Inspector's Report ABP-305239-19

Whether the erection of a 1.2m high boundary wall at Grange, Kilmallock, Co. Limerick is or is not development or is or is not exempted development.

Grange, Kilmallock, Co. Limerick

SITE LAYOUT
SCALE 1:250

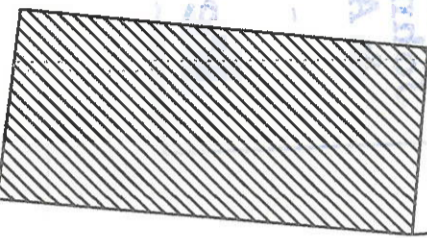
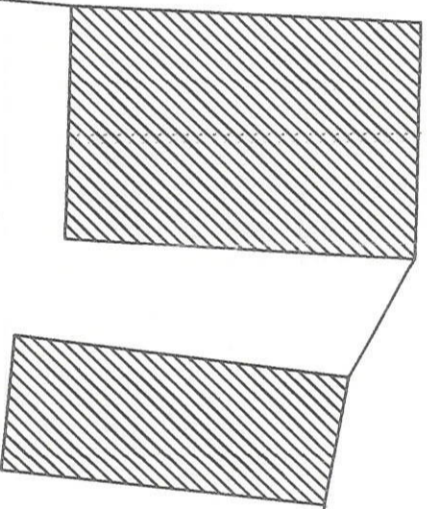
- 8.2.1. The question refers to the erection of a 1.2m high boundary wall on the subject site. A site layout plan shows that this wall would be erected around the open portions of the perimeter to this site so as to achieve its complete enclosure in connection with its use as a private garden. (Access would be by means of an existing pedestrian gate in the existing wall along the eastern boundary). The proposed wall would be either 1.1m or 1.2m in height, i.e. the wall elevation on the site layout plan shows the former height and the submitted application form cites the latter height. For the purpose of my assessment, I will work to the higher of these two heights. This wall would be formed from concrete blockwork and it would be capped and plastered.

- 8.4.3. The site layout plan indicates that the wall would abut the back of the recently constructed kerb lines to the adjoining carriageways and so the proposed wall would effectively introduce upright structures that would be immediately adjacent to these carriageways. The presence of such structures would have the effect of prompting drivers to allow a greater clearance between them and their vehicles. Such “lying over” at a junction would add to the inherent hazard of vehicular movements at this junction and so it would “endanger public safety by reason of traffic hazard.” I, therefore, consider that Item (iii) is applicable.
